PREPARED BY:
TERRA NOVA ENGINEERING, INC.

Jobs/2419.00/Drainage/241900 FDR.doc

***PLATTE SELF STORAGE
AREA RUNOFF COEFFICIENT (C) SUMMARY***

PLATTE SELF STORAGE
SITE DEVELOPMENT PLAN
EXISTING DRAINAGE MAP
AUGUST 2024

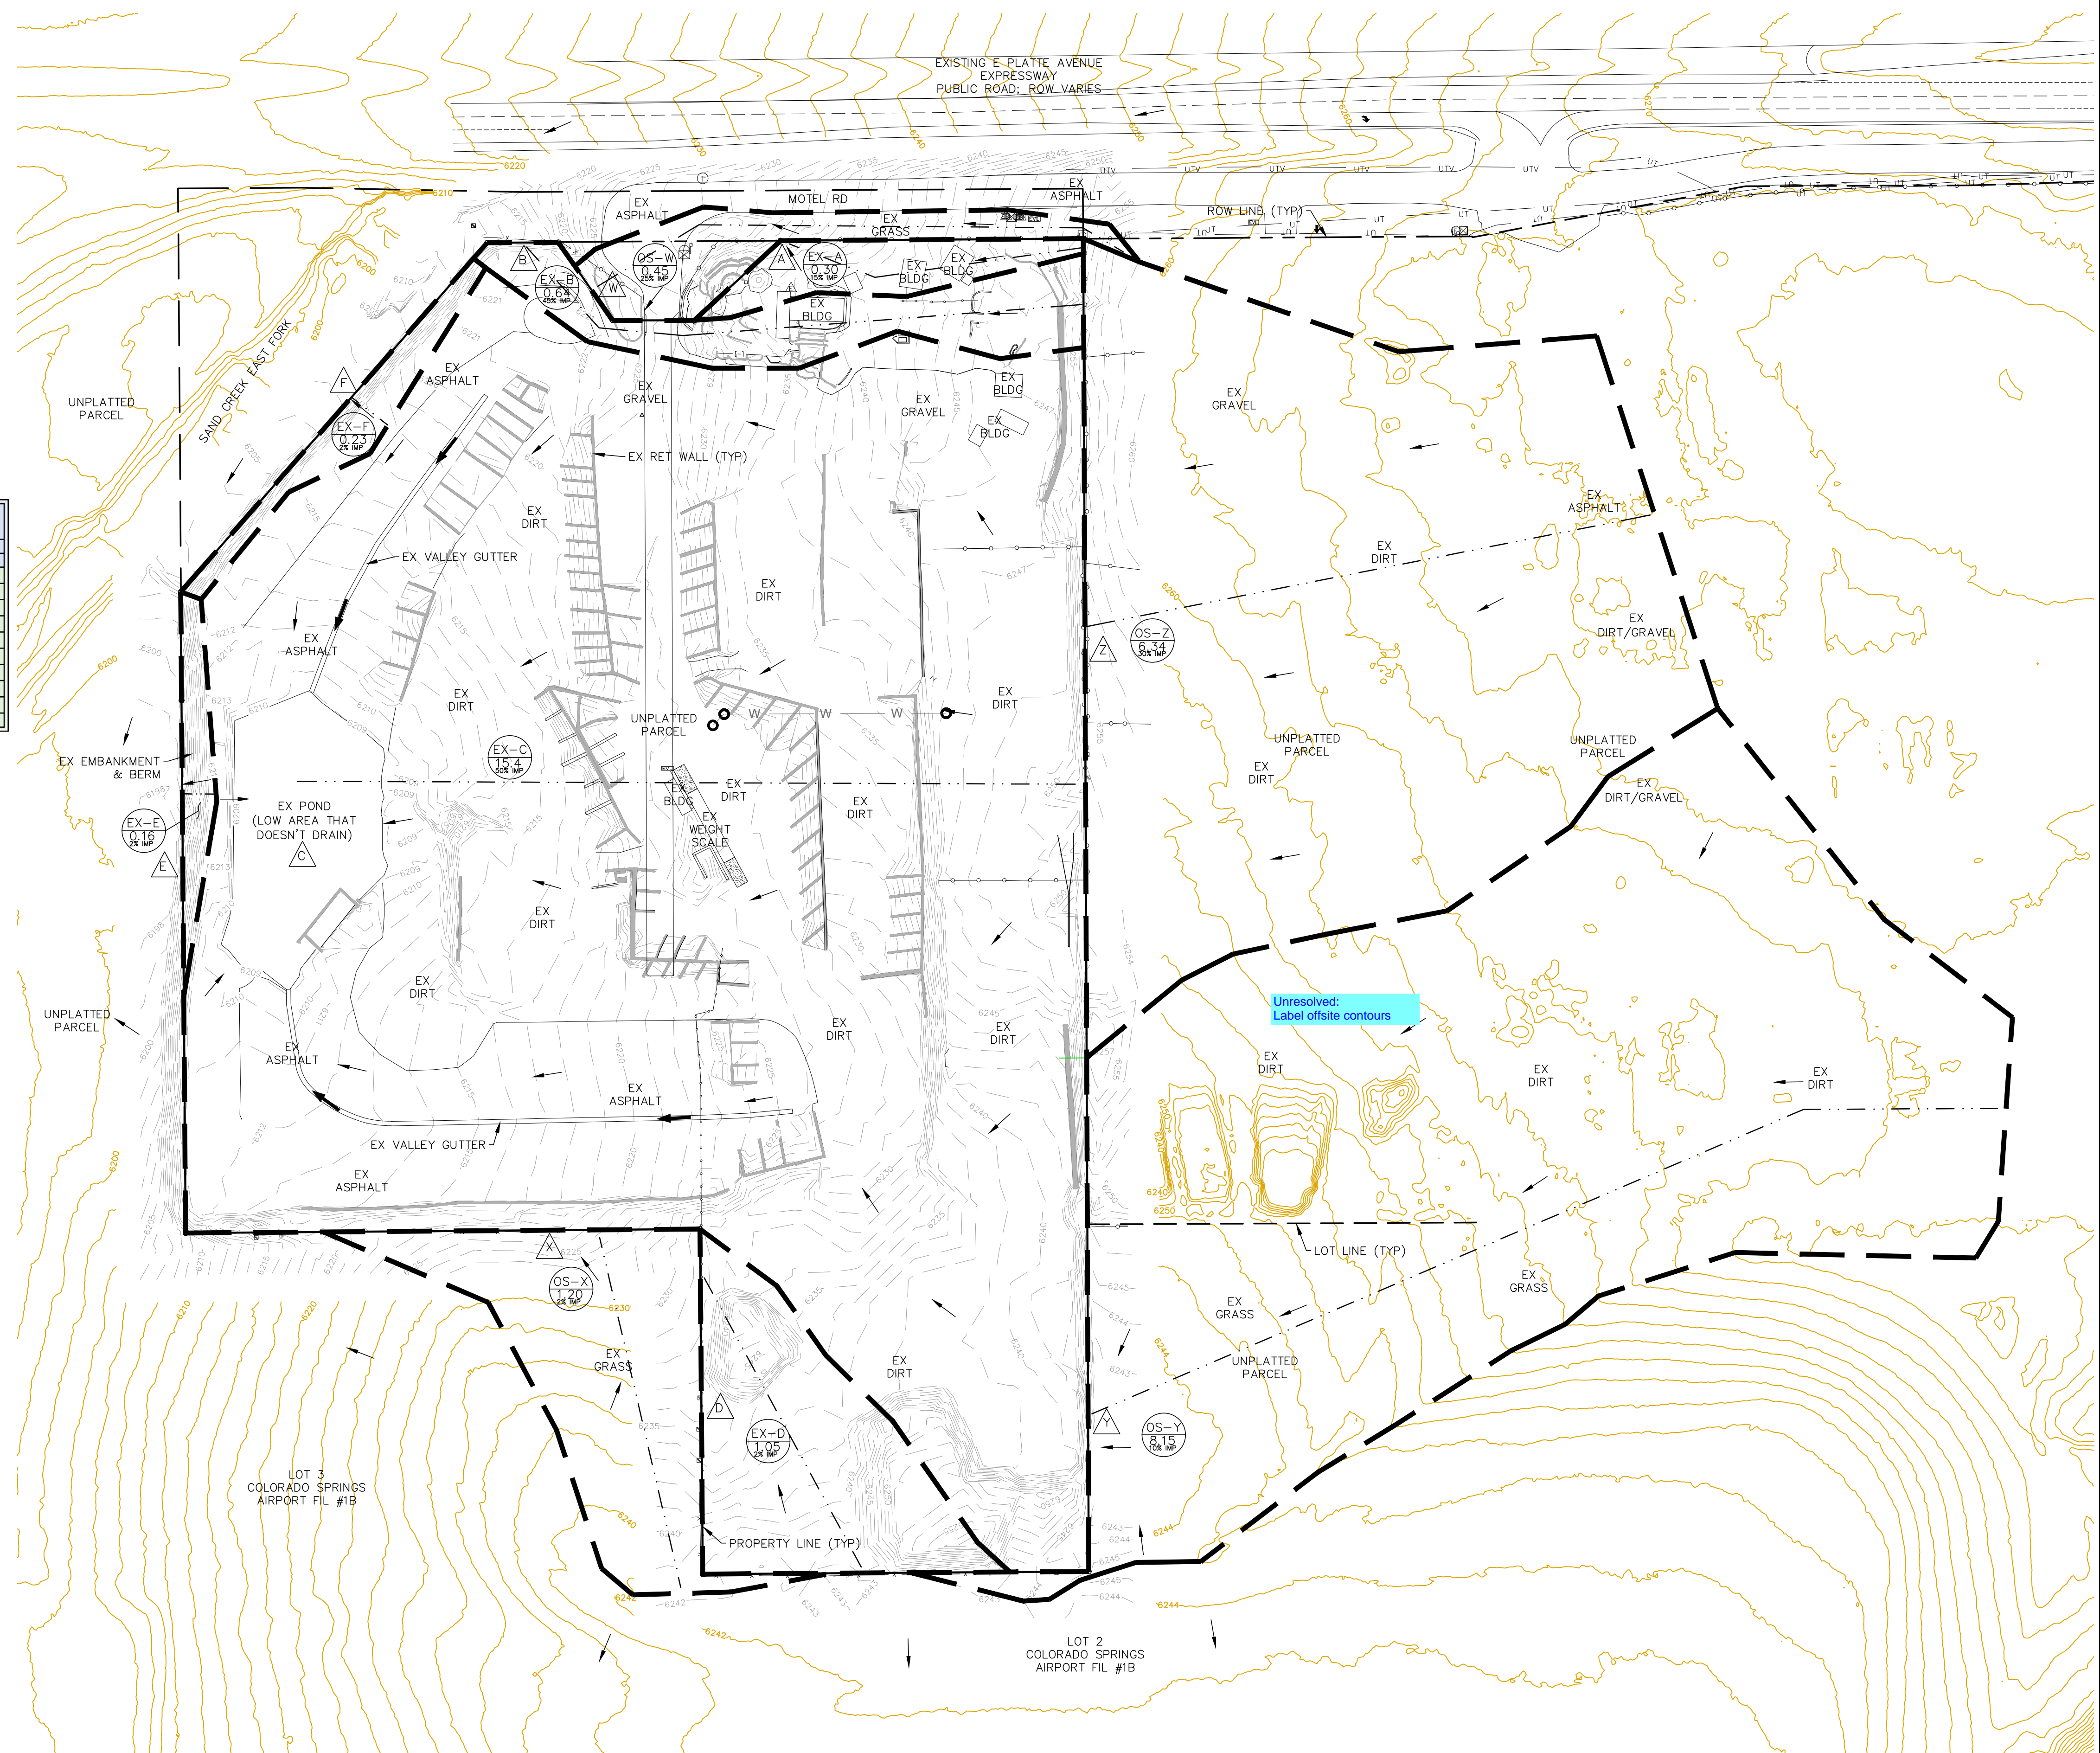
Unresolved:
Please show & label all
drainage easements.

We have shown
a ditch and
access point for
pond and road

STILLING BASIN DETAIL
NOT TO SCALE

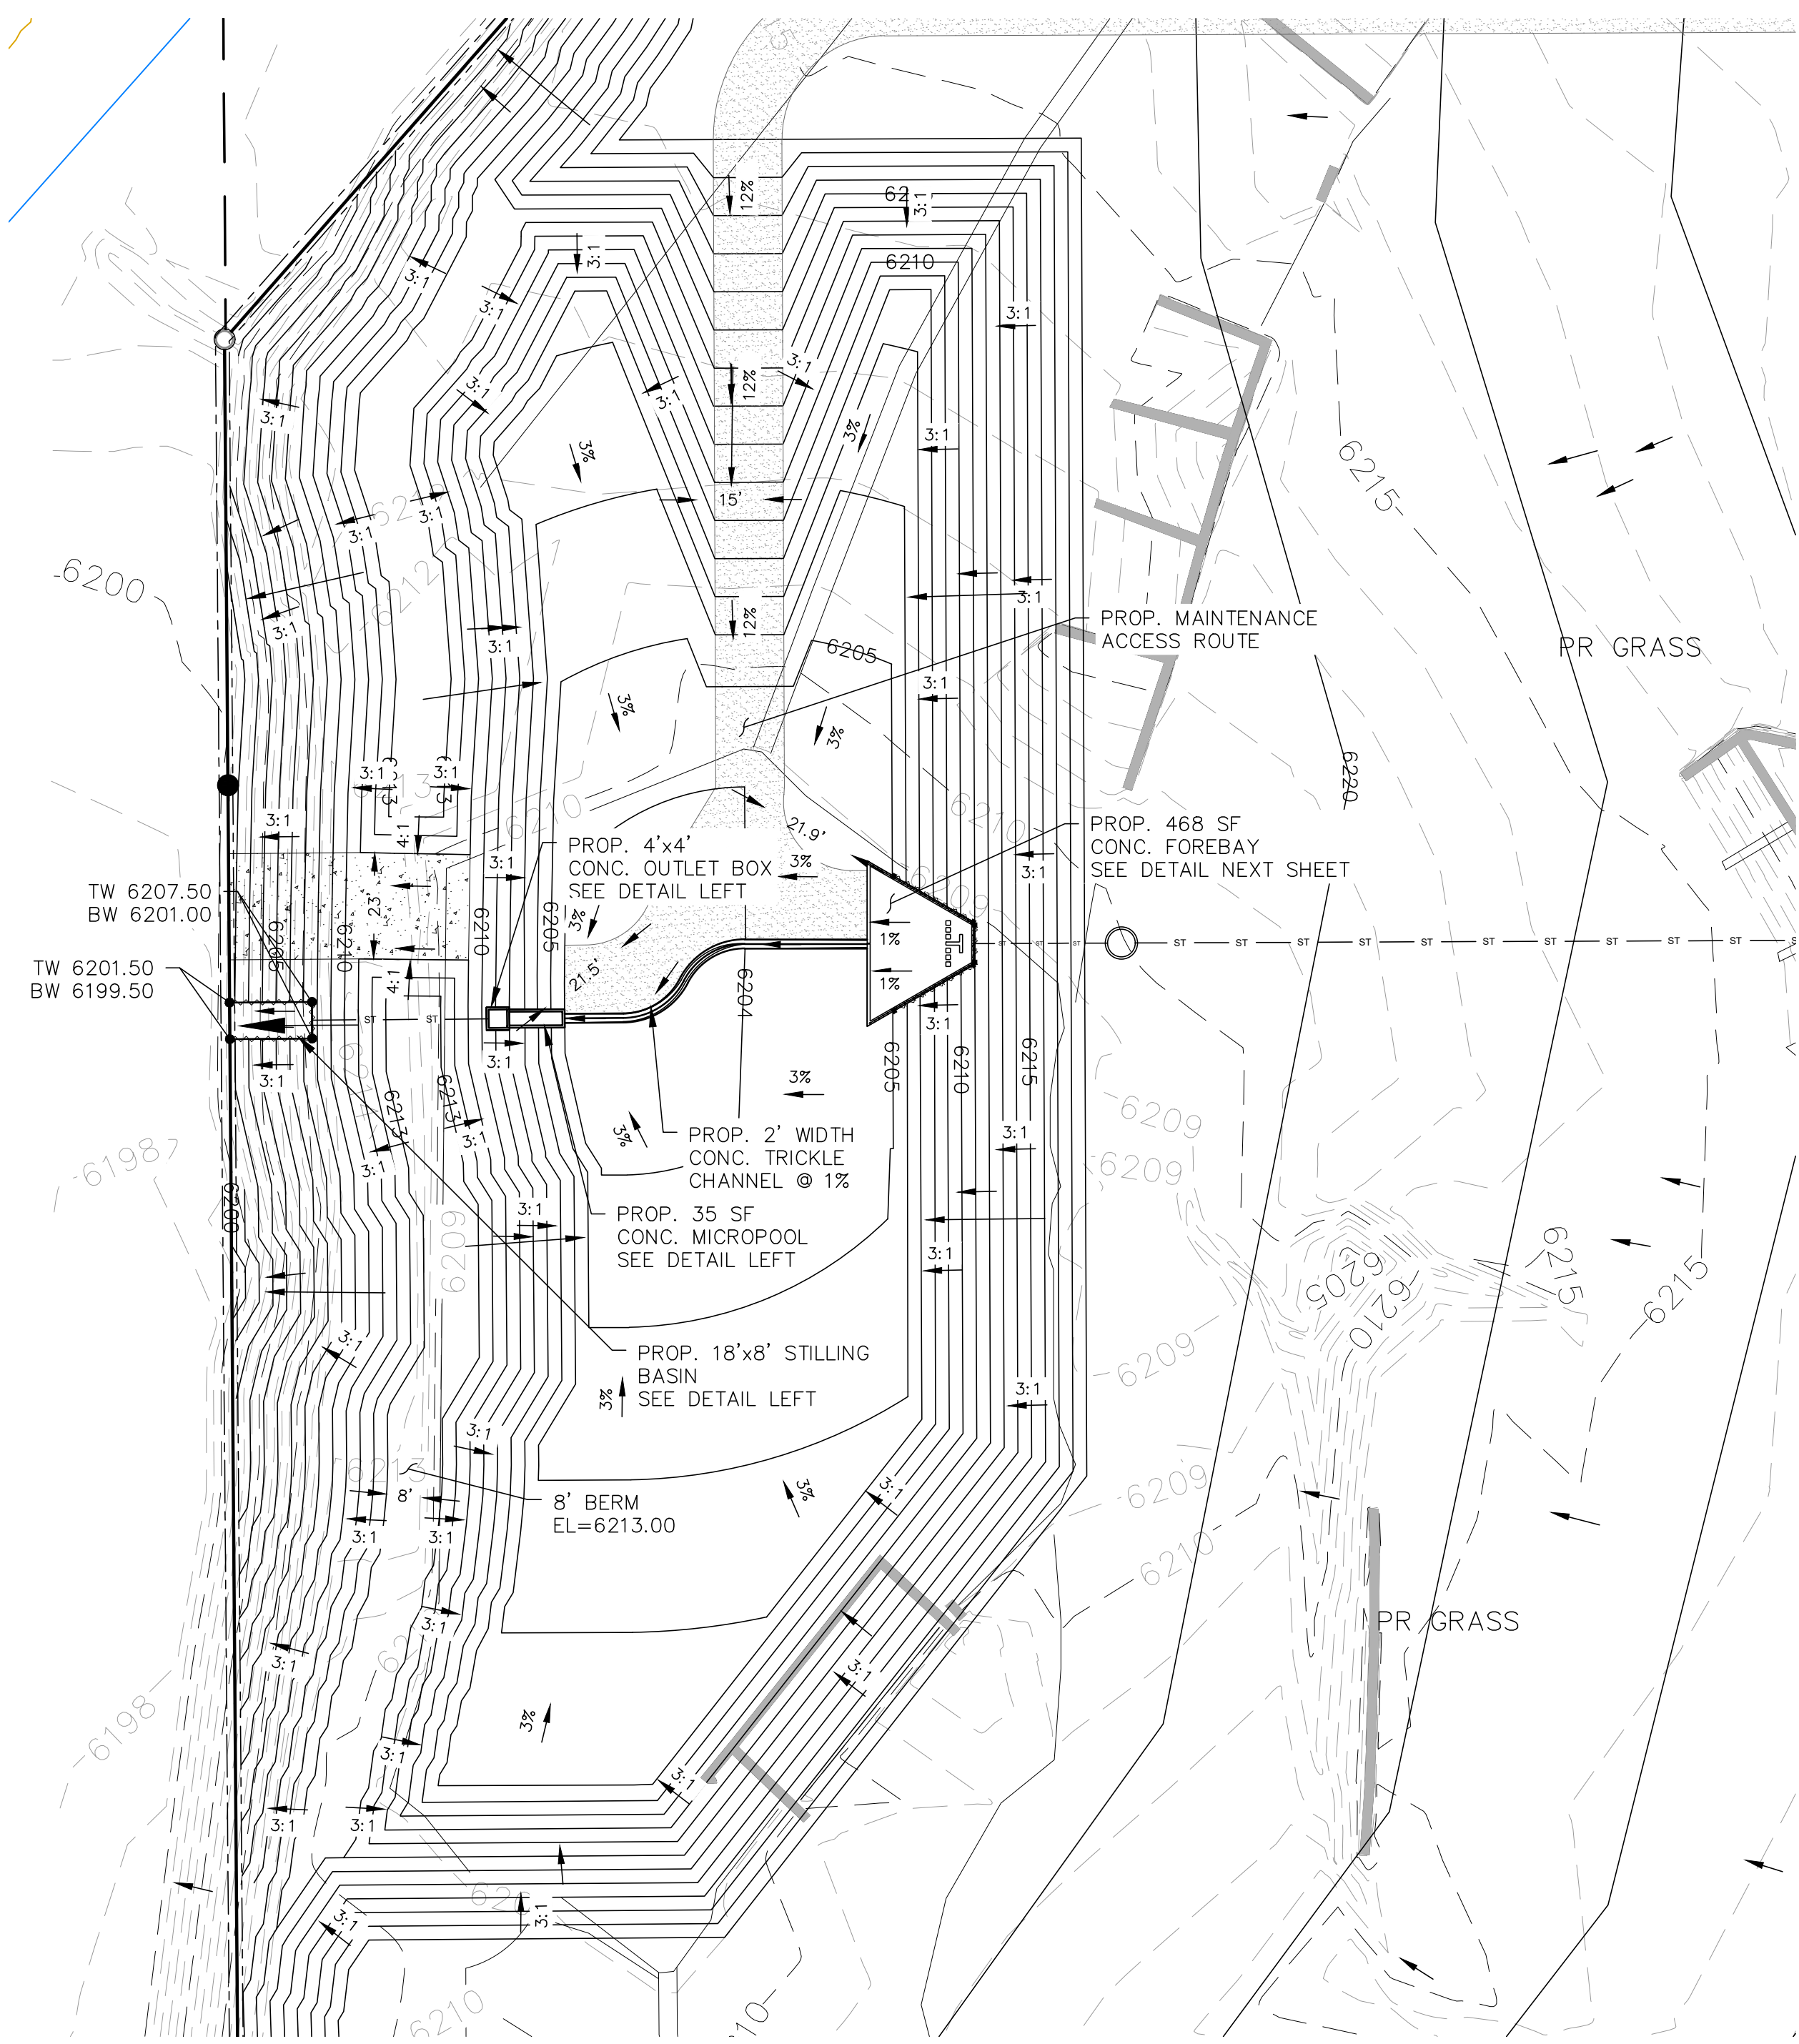
Unresolved:
Provide calculations in appendix
for sizing of stilling basin

See Appendix
for notes
